**RESPONSE TO SUBMISSIONS - MOD 6 TO MP08_0238
1 DENISON STREET, NORTH SYDNEY**

We write on behalf of Winten Property Group (Winten) in regards to the Section 75W modification application being MOD 6 to Project Approval MP08_0238 relating to the construction of a new commercial building at 1 Denison Street, North Sydney.

1 Denison Street, North Sydney (MOD 6)

Response to Submissions

BATESSMART™

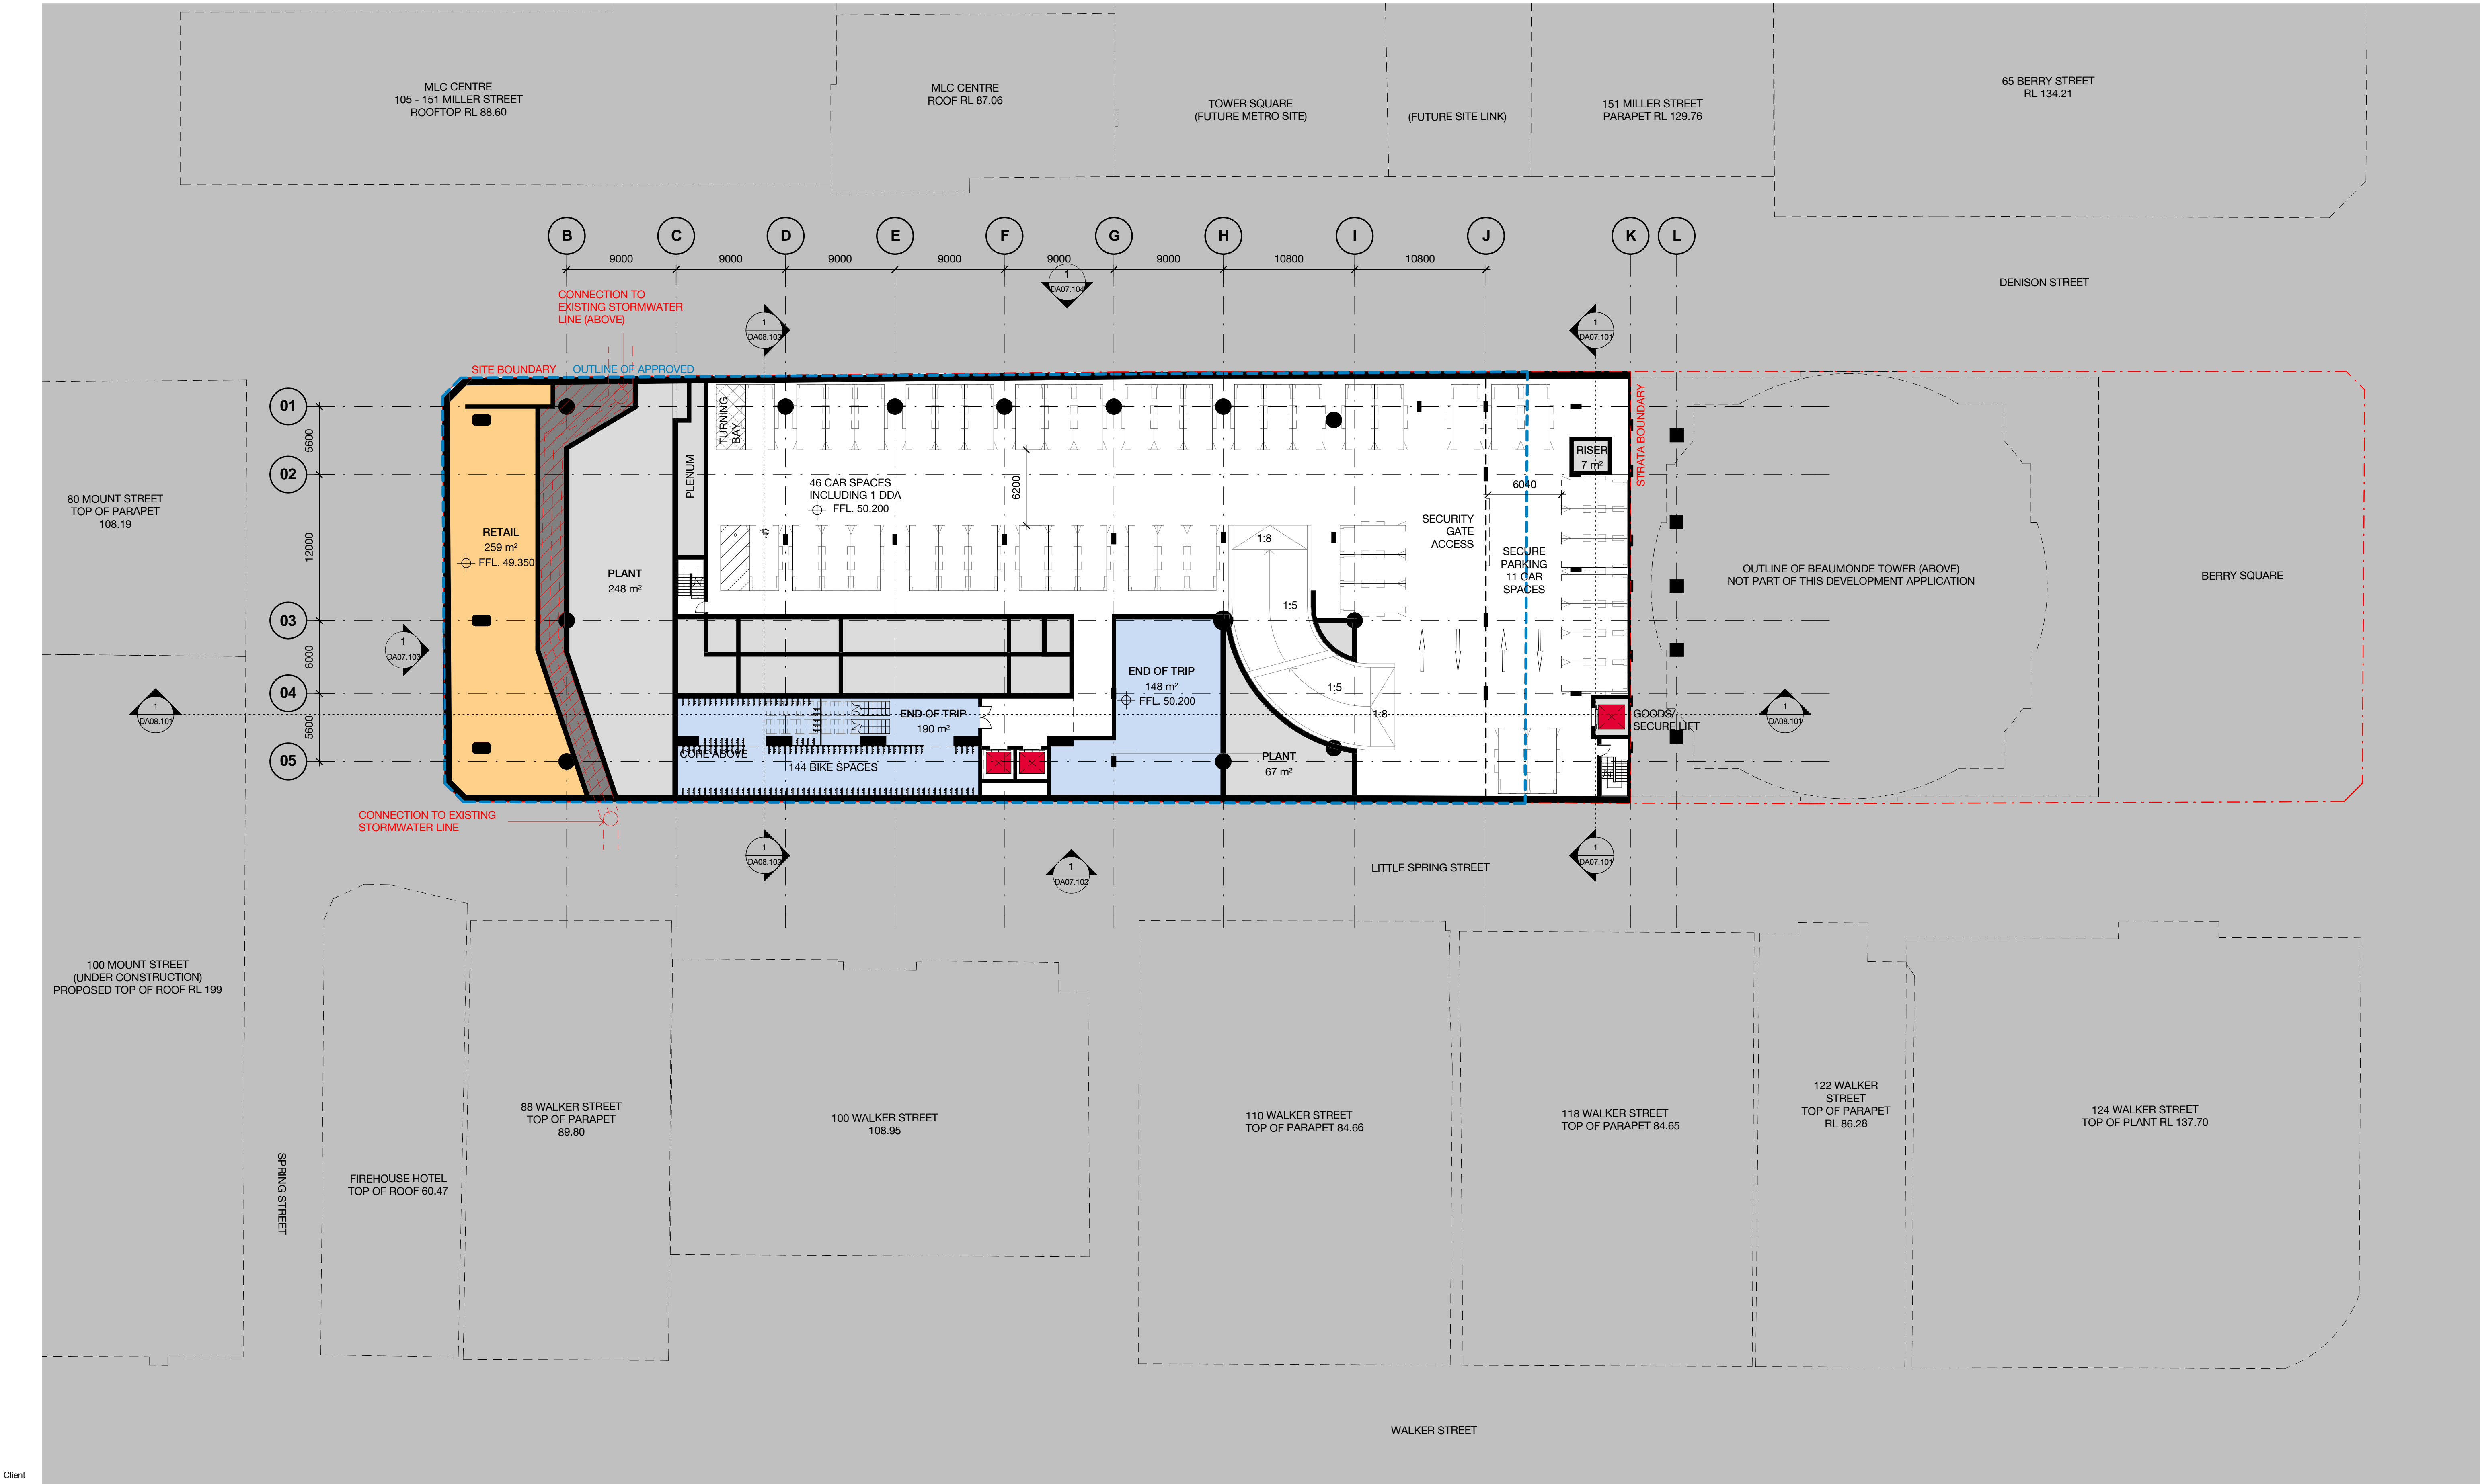
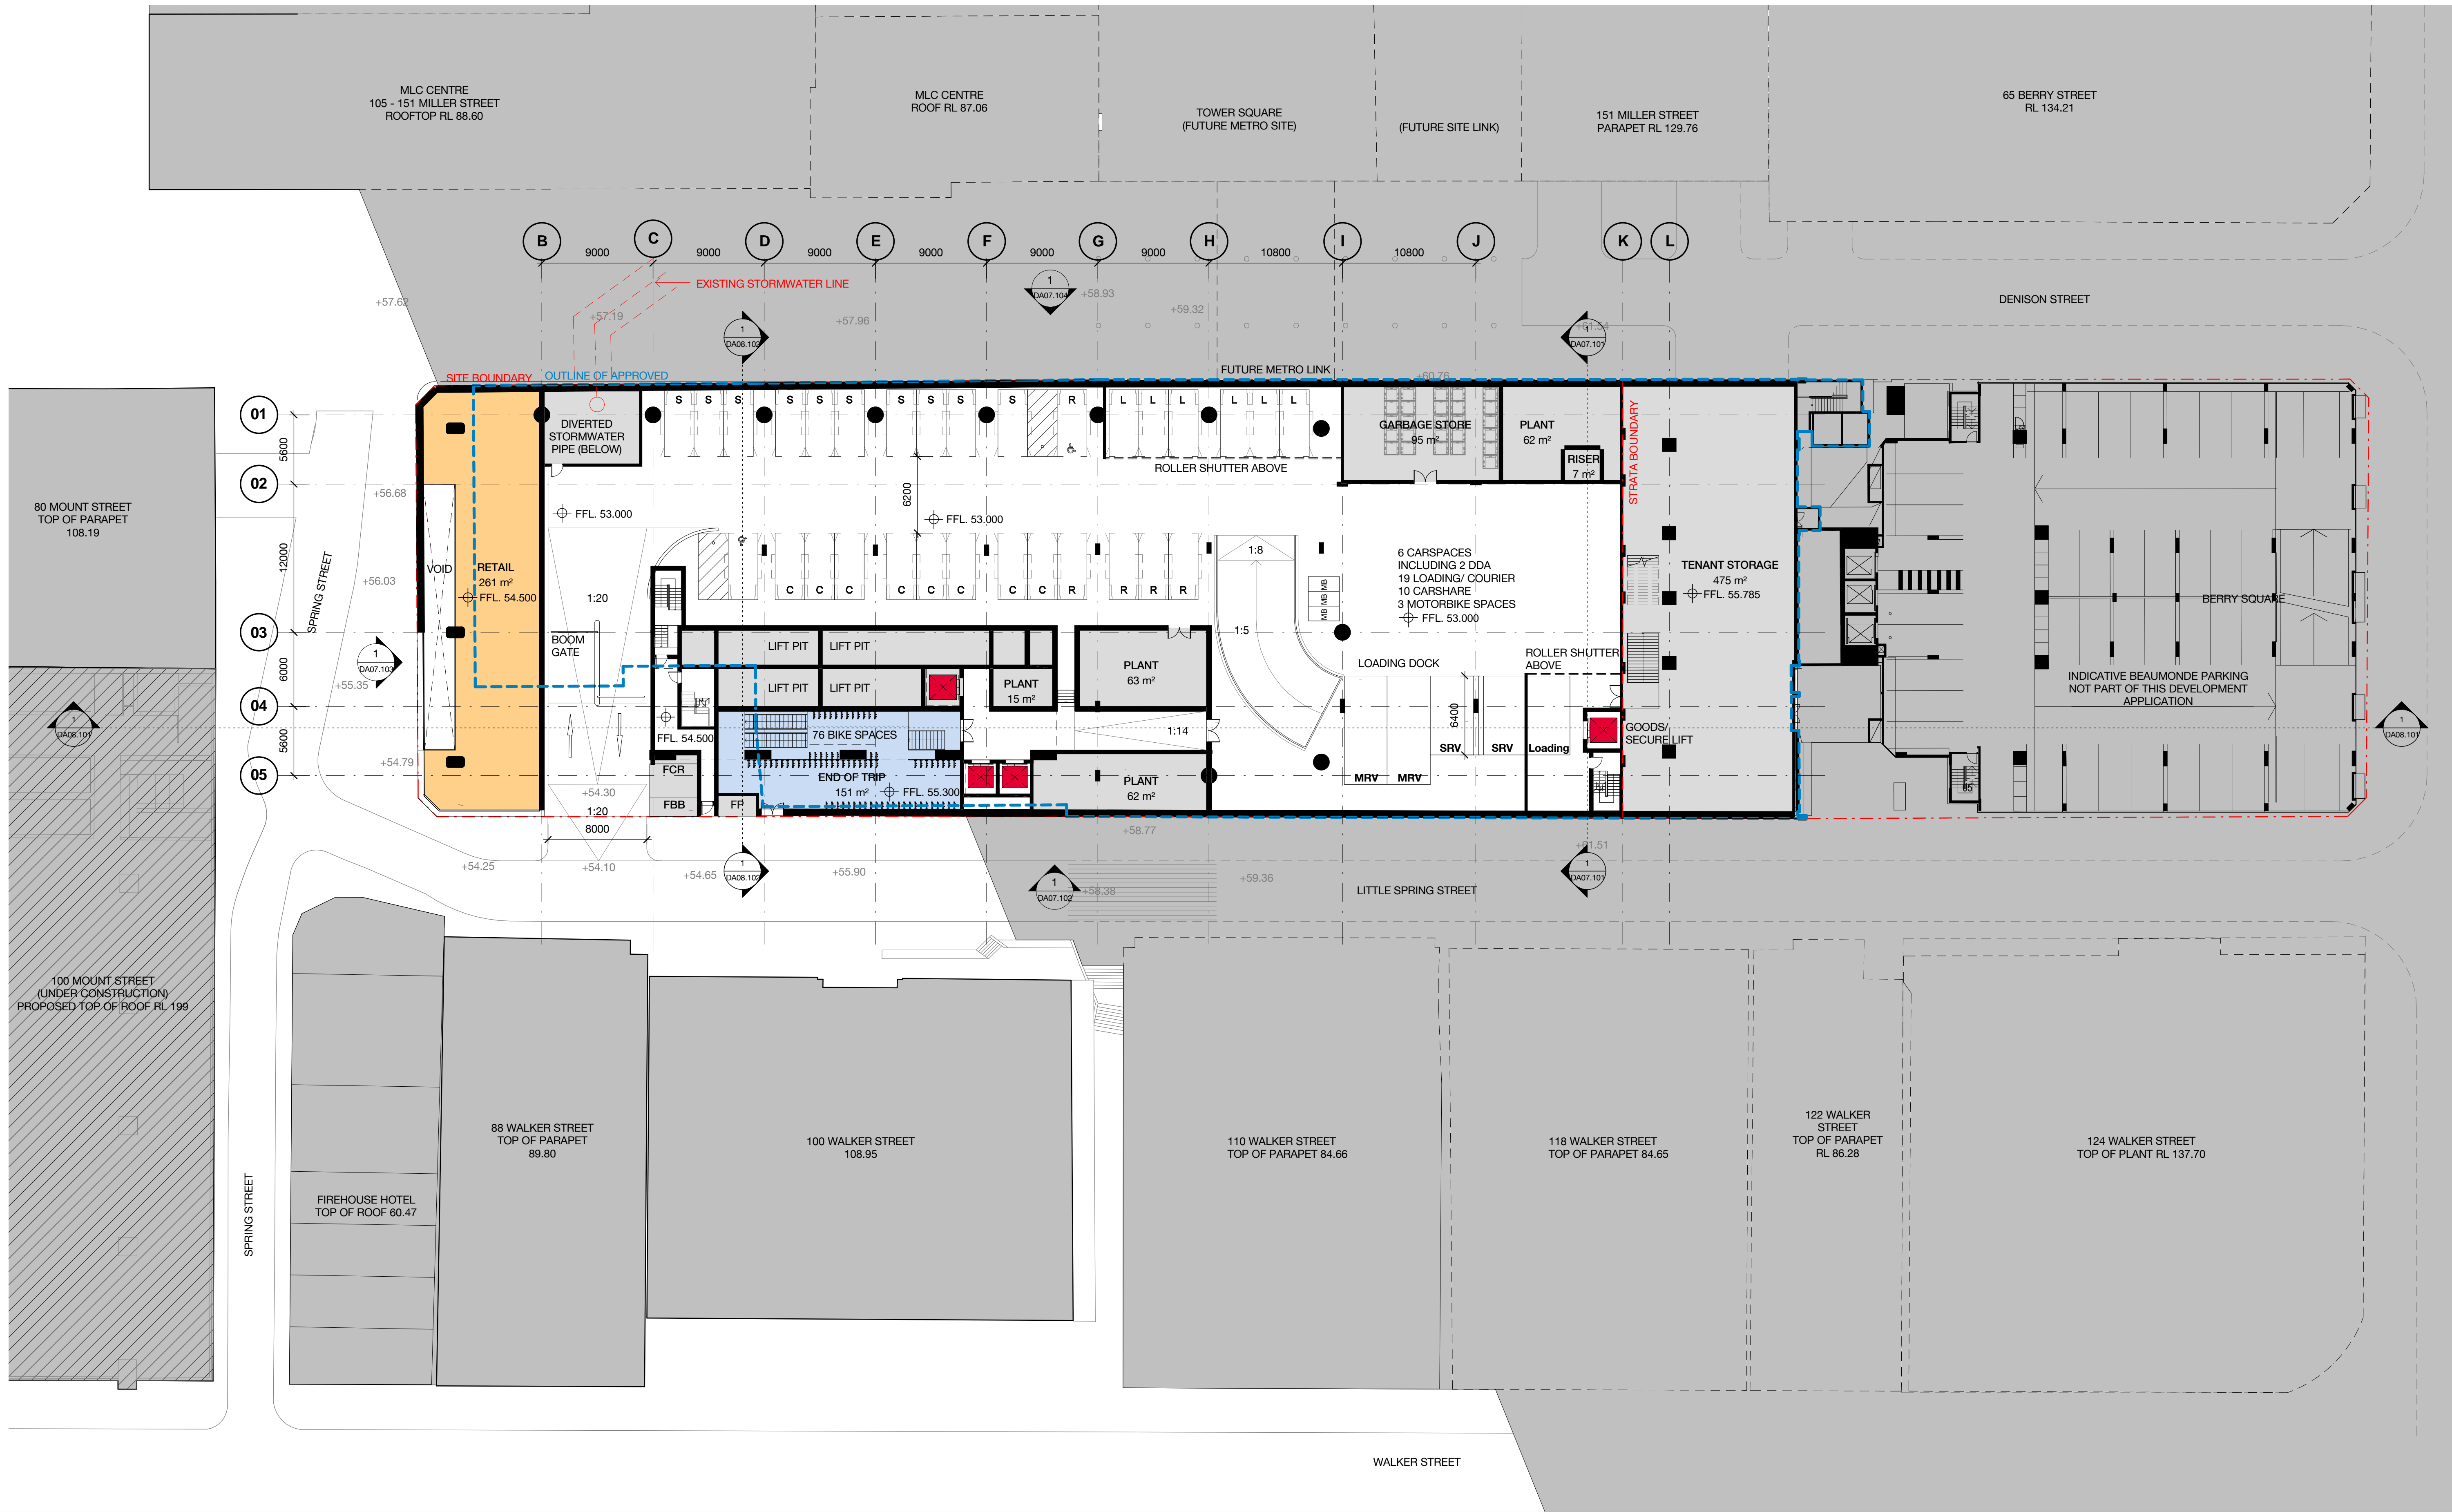
The amended plans (**Attachment B**) reinstate 32 public car parking spaces in response to the submission on behalf of North Sydney Council (Council). These public car spaces, in addition to the 10 car share places proposed as part of MOD 6, will provide a total of 42 car spaces for public use, consistent with the original approval of MP08_0238. The proposed public car spaces will be retained in ownership by the developer and managed as a public car park.

<p>The Department of Planning and Environment may be advised that Council:</p> <ol style="list-style-type: none"> Does not support the previously approved 22 space public car park on site being replaced by car share parking and tenant parking. Does not agree to the loss of 40 on street car spaces without an appropriate offset being provided for onsite, Seeks reinstatement of the public parking to offset the loss of on street parking for a minimum of 40 spaces. 	Following further discussions with Council in light of its submission, the proposed development has been amended to include 10 car share spaces and 32 public car spaces – totalling the 42 spaces originally approved. The ownership and management of these public car park spaces will be retained by the proponent.
The Department of Planning and Environment be advised that the under-provision of bicycle parking, particularly for a significant commercial development in the heart of the North Sydney CBD, will undermine the intent of Council's DCP and transport policies.	The provision of bicycle parking has been increased from 220 to 570 and will be provided at the rate consistent with the requirements of 5-star Green Star rating. Whilst the proposed provision remains under Council's requirement of 710 spaces, 5-star Green Star is classified as Australian best practice sustainability, and therefore it is considered unreasonable to request a provision of bicycle spaces in excess of this standard. We also note that this is a substantial increase from the approved bicycle parking of 161 spaces.

A revised Traffic and Parking Assessment, prepared by Arup and submitted at **Attachment C**, confirms that the changes to the basement car park and provision of additional public car parking will not generate any measurable impact on the surrounding road network as these public car spaces will provide replacement of existing on street parking lost through the redevelopment of the site. Therefore the revised basement and car parking is considered appropriate for the site. A summary of the revised total car parking provision within the development is provided in **Table 1**.

<i>Condition B43 – Bicycle Storage and Parking</i> Comment: The proposed quantity of bicycle parking is less than half the minimum required under Council's DCP. The rates set in the DCP were a deliberate policy decision by Council to encourage the use of bicycles as an environmentally beneficial form of transport and an alternative to the use of private motor vehicles. The under-provision of bicycle parking by 60%, particularly for a significant commercial development in the heart of the North Sydney CBD, will undermine the intent of the DCP and Council's transport policies. The Department is requested to insist on additional bicycle parking.	The proposed provision of bicycle parking has been increased from 220 to 570 and will be provided at the rate consistent with the requirements of 5-star Green Star rating. Whilst the proposed provision remains under Council's requirement of 710 spaces, 5-star Green Star is classified as Australian best practice sustainability, and therefore it is considered unreasonable to request a provision of bicycle spaces in excess of this standard. We also note that this is a substantial increase from the approved bicycle parking of 161 spaces.

The amended plans (**Attachment B**) include an increase in the provision of bicycle parking in response to the submission of Council. The provision of bicycle parking has been increased to meet the requirements of 5-star Green Star building rating, providing a total of 570 bicycle spaces, including end of trip facilities, as detailed in the amended plans. Although the proposed bicycle parking remains non-compliant North Sydney Development Control Plan provision; 5-star Green Star is considered the industry best practice standard and therefore considered the most appropriate standard for the development. Further, the increased provisions represents an additional 409 spaces to that of the approved development (refer to **Table 2**). It is noted that should demand for the bicycle spaces increase above provision in the future then car spaces within the tenant car park could be converted to additional bicycle spaces.
